**From:** [Carolyn Holtzen](#)  
**To:** [Jamey Ayling](#); [CDS User](#)  
**Subject:** Public Comments on CU-23-00003 Fowler Creek Guest Ranch  
**Date:** Wednesday, October 18, 2023 6:19:32 PM

I live at 164 Powder Drive, Cle Elum and I am writing to express my concern about the Fowler Creek Guest Ranch (CU-23-00003).

FOWLER CREEK GUEST RANCH
EXHIBIT 12
EMERGENCY INGRESS AND EGRESS PLAN

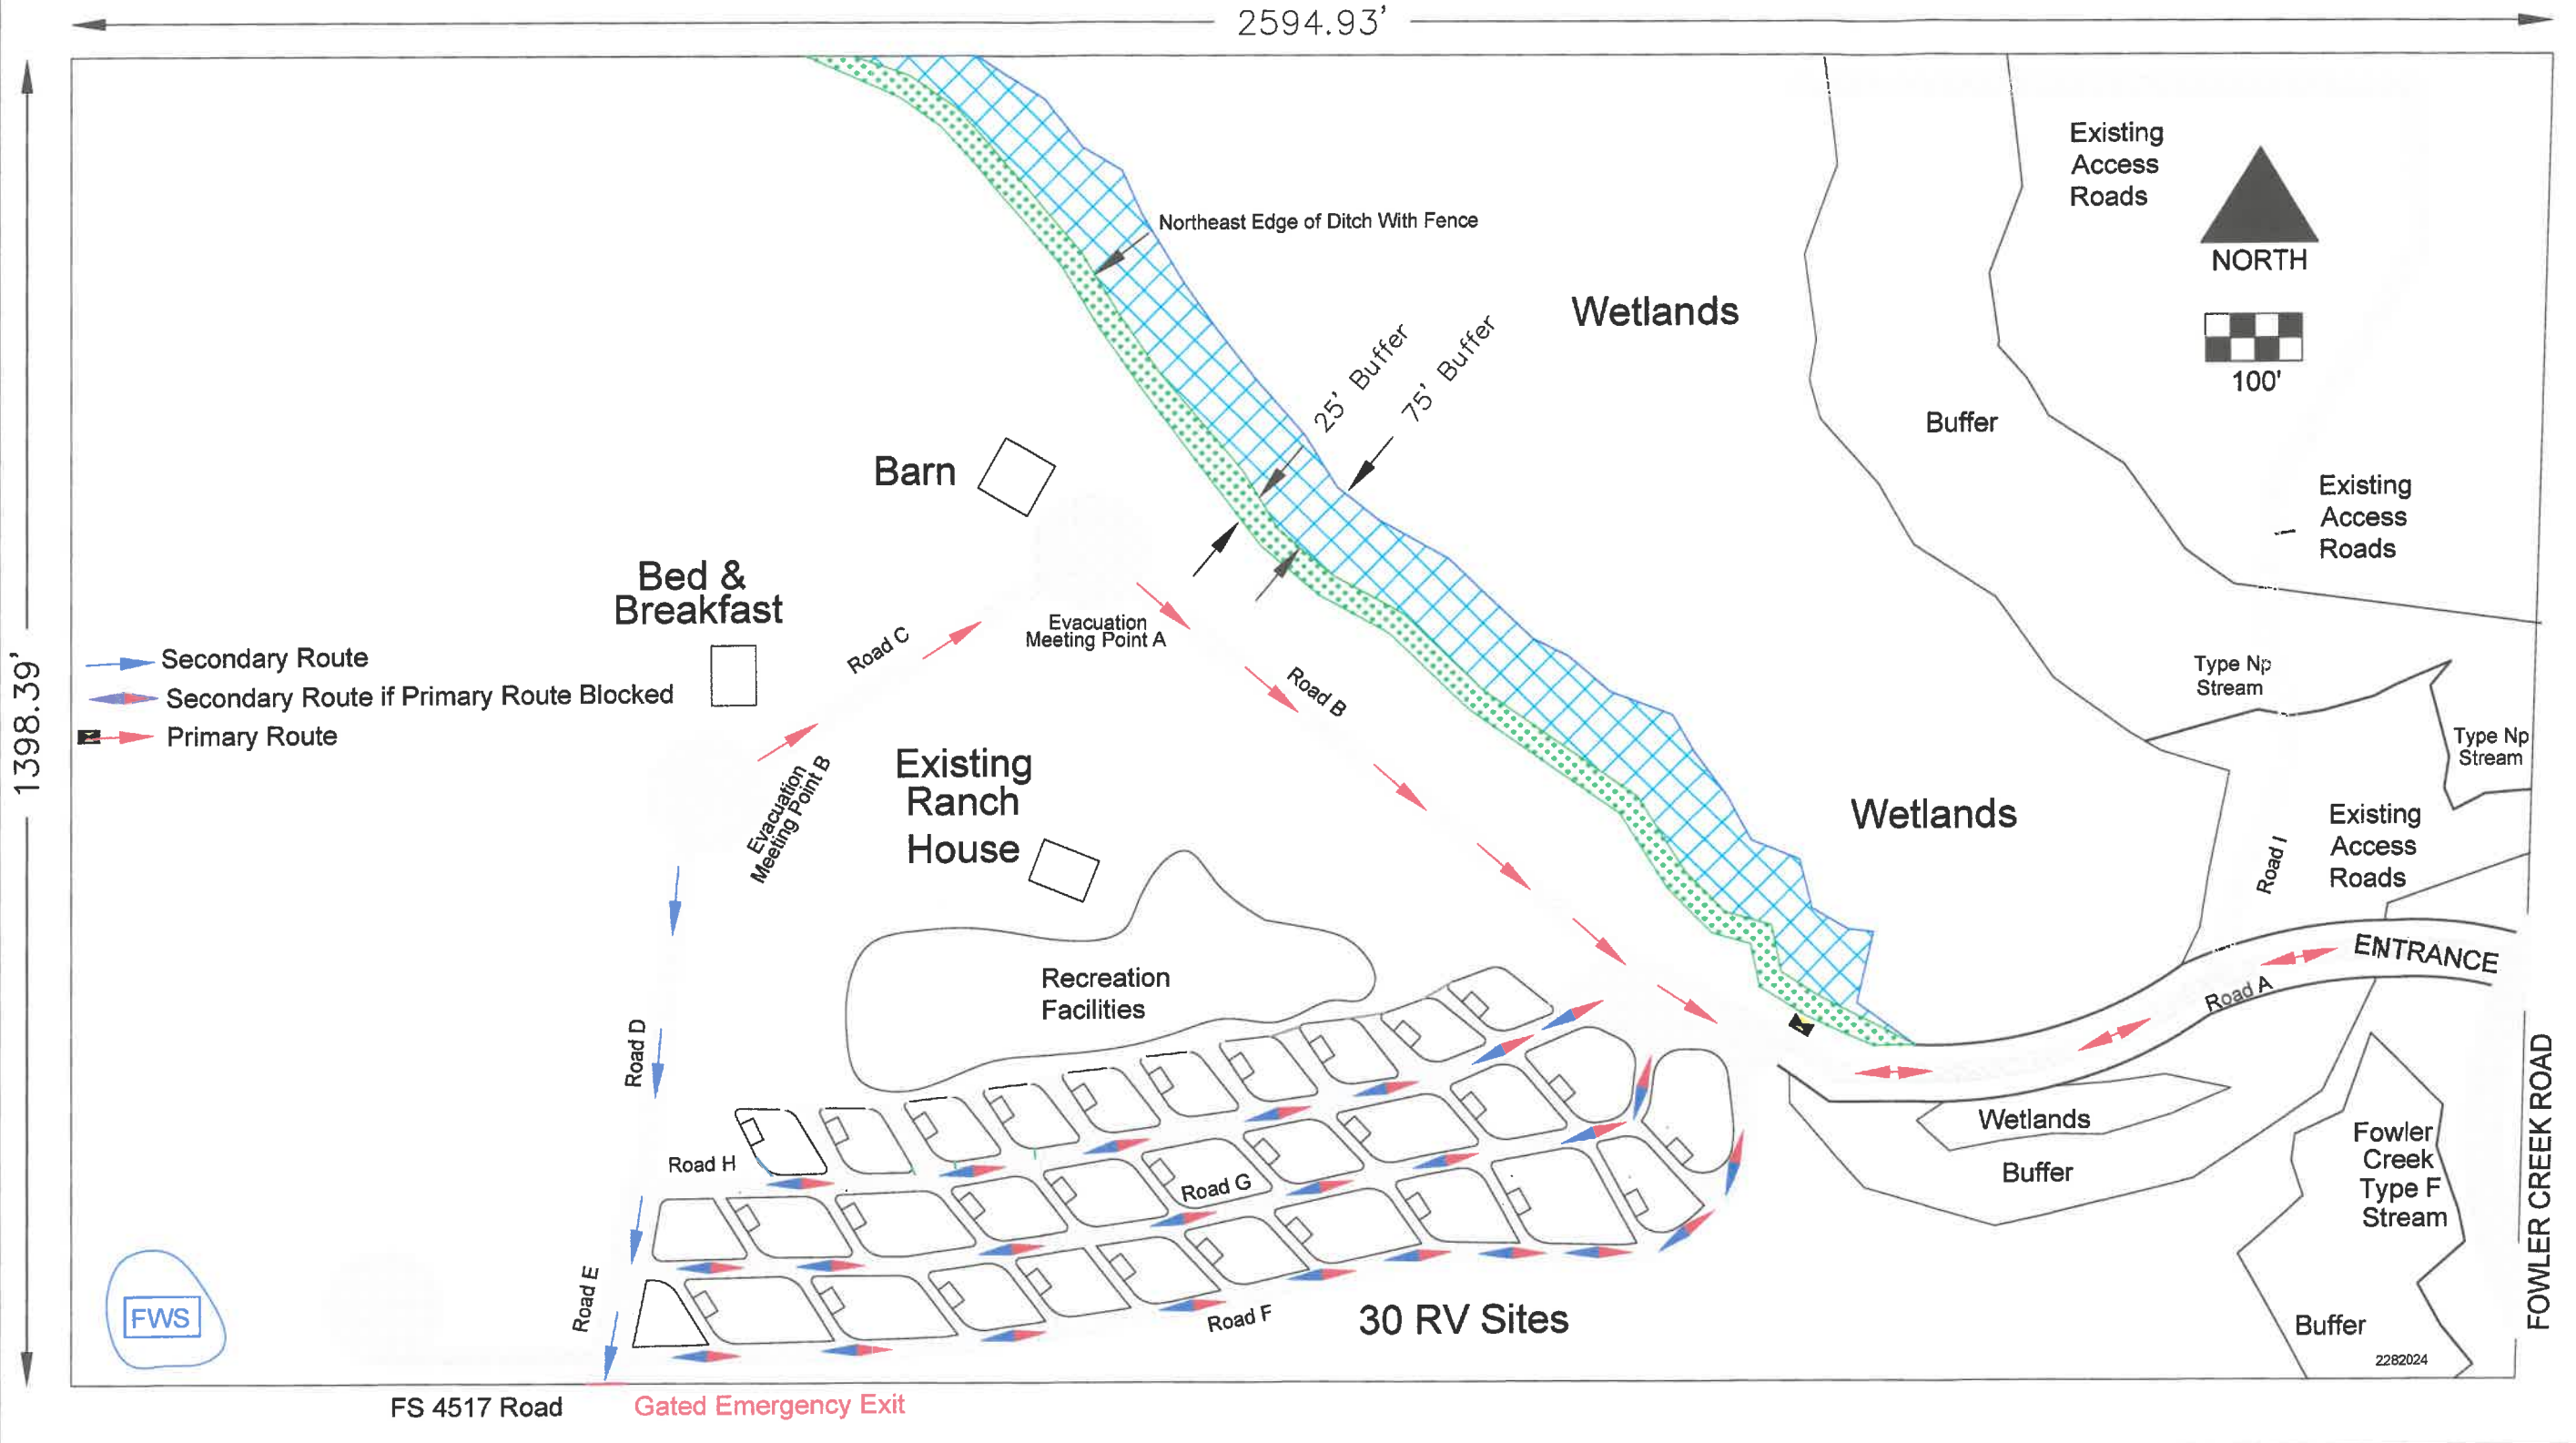
- Significant increase in ATV traffic - application specifically states that ATVs will not be allowed to use trails on property and can only exit out FS 4517, which means this would lead to a significant increase in ATV usage on roads through Granite Creek community and in surrounding National Forest land

- Exit on FS 4517 - the stretch of FS 4517 that intersects with Fowler Creek is steep and the iciest portion of the road in the winter. My husband has ended up in the ditch on the side of the road on this stretch, as have other neighbors. This is not a safe exit for traffic from the proposed development - and definitely not RVs! My father-in-law got his RV trailer stuck due to the grade, had to call a tow truck and never tried again.

SEWAGE MANAGMENT SITE PLAN MAP - FOWLER CREEK GUEST RANCH

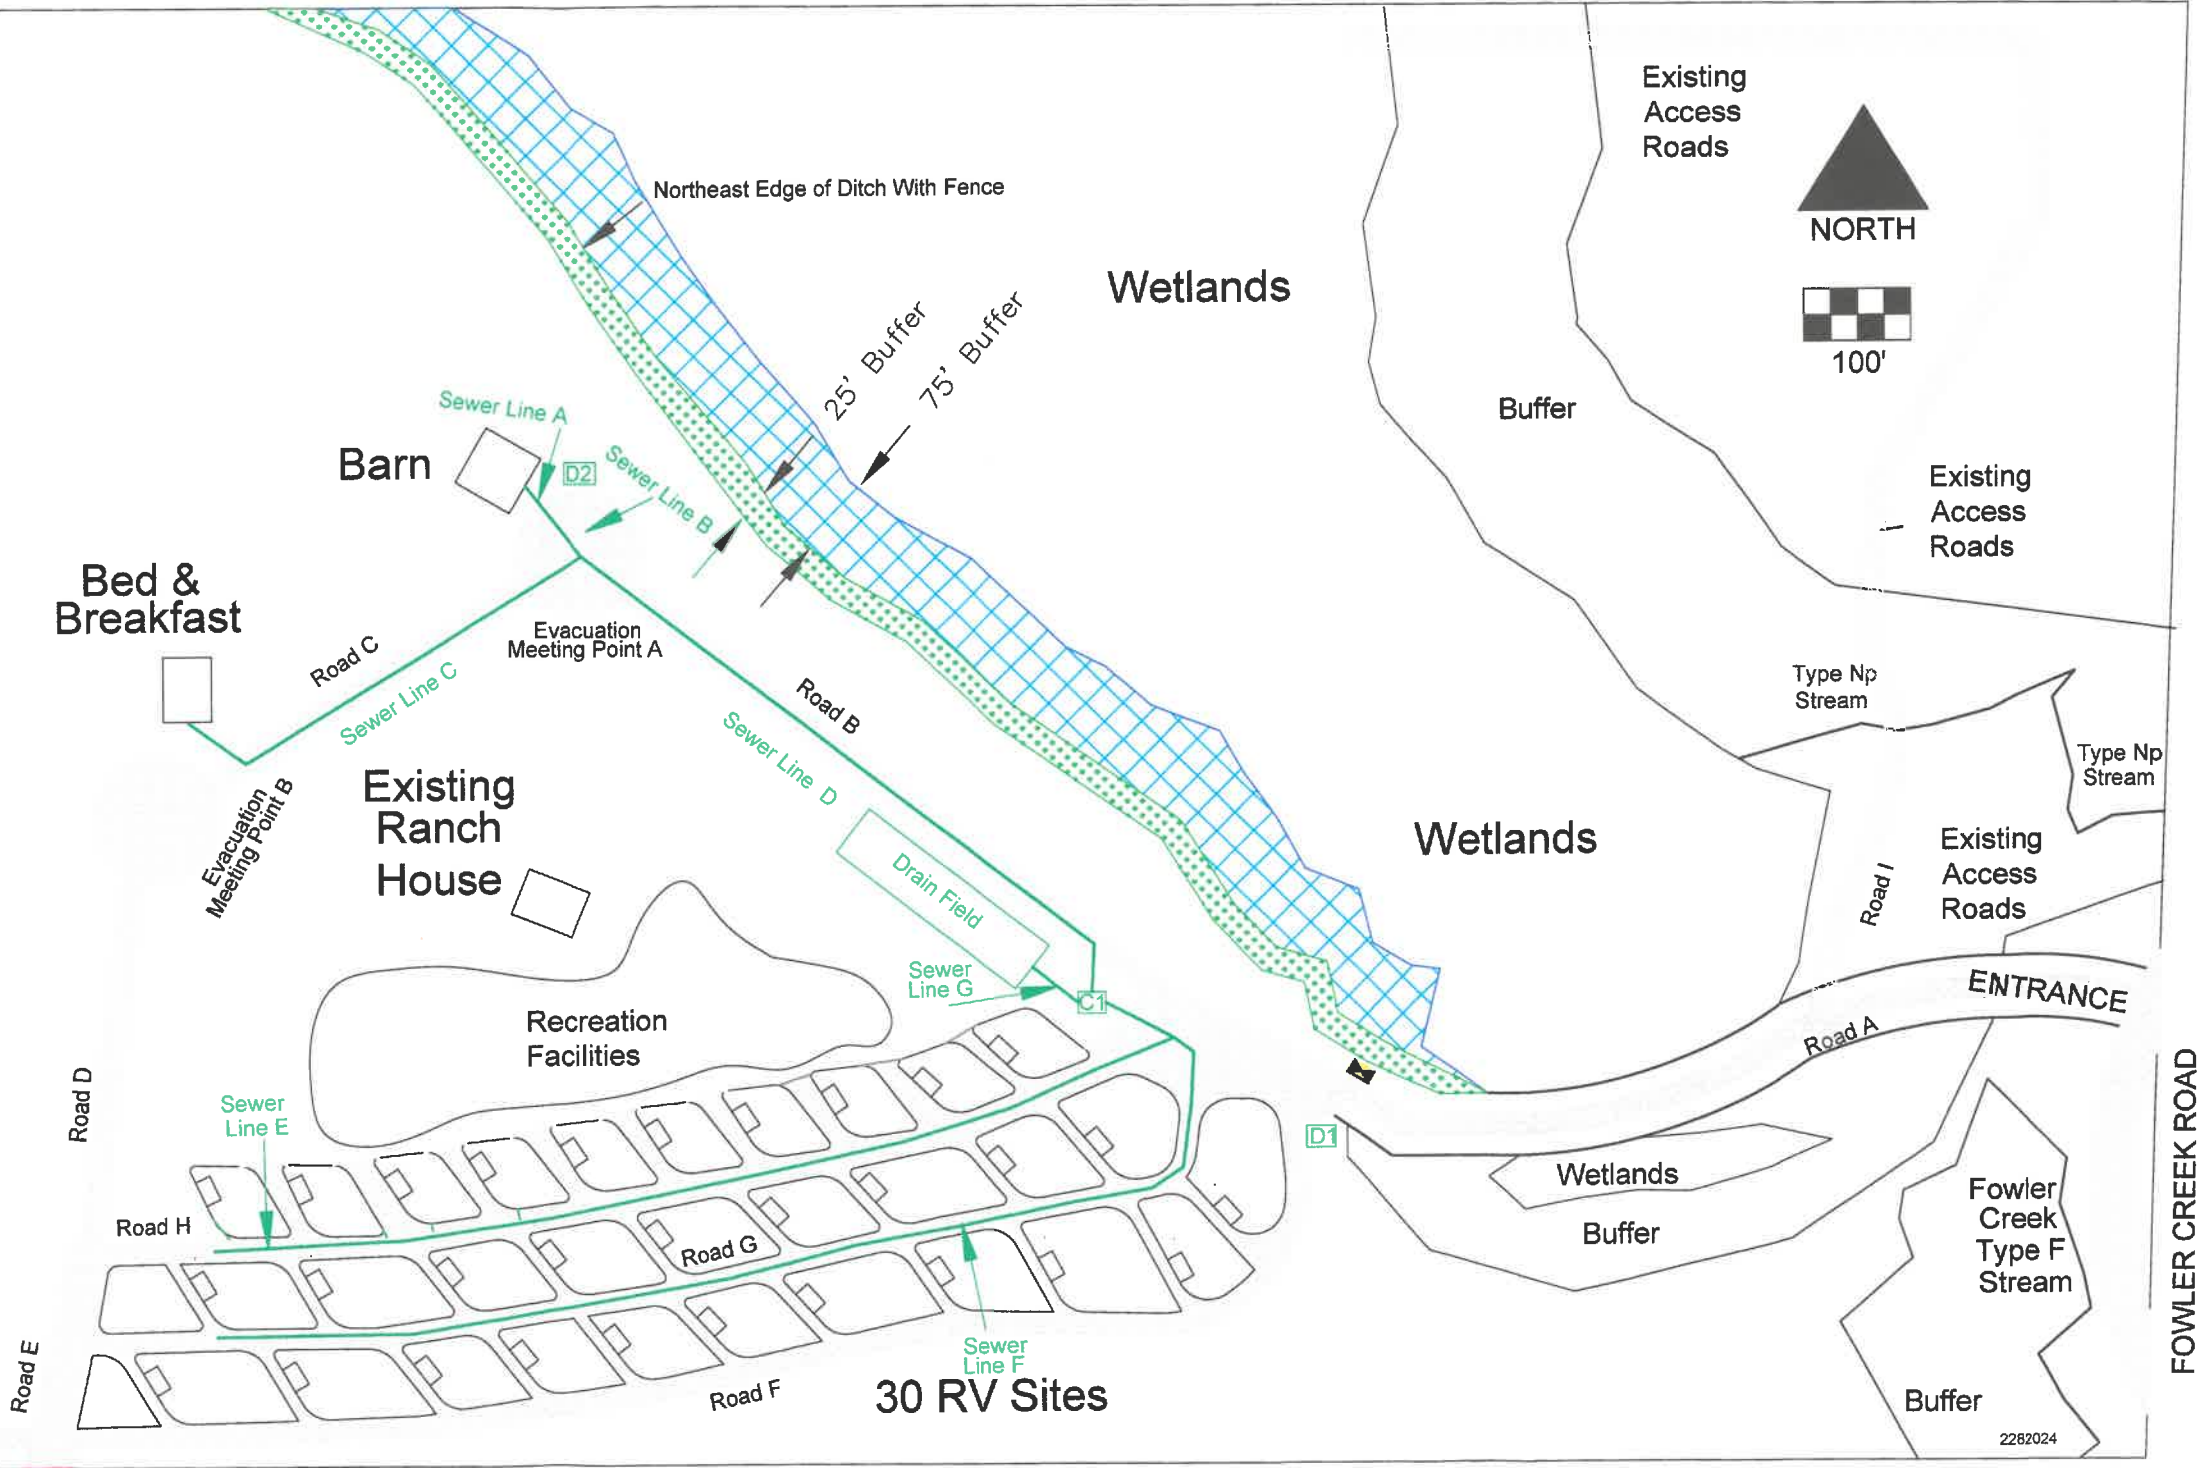
- Sewage management: Given the wetlands on the property I have significant concerns about how sewage for 150 people's regular usage will be managed and not pose a health risk to people and animals.
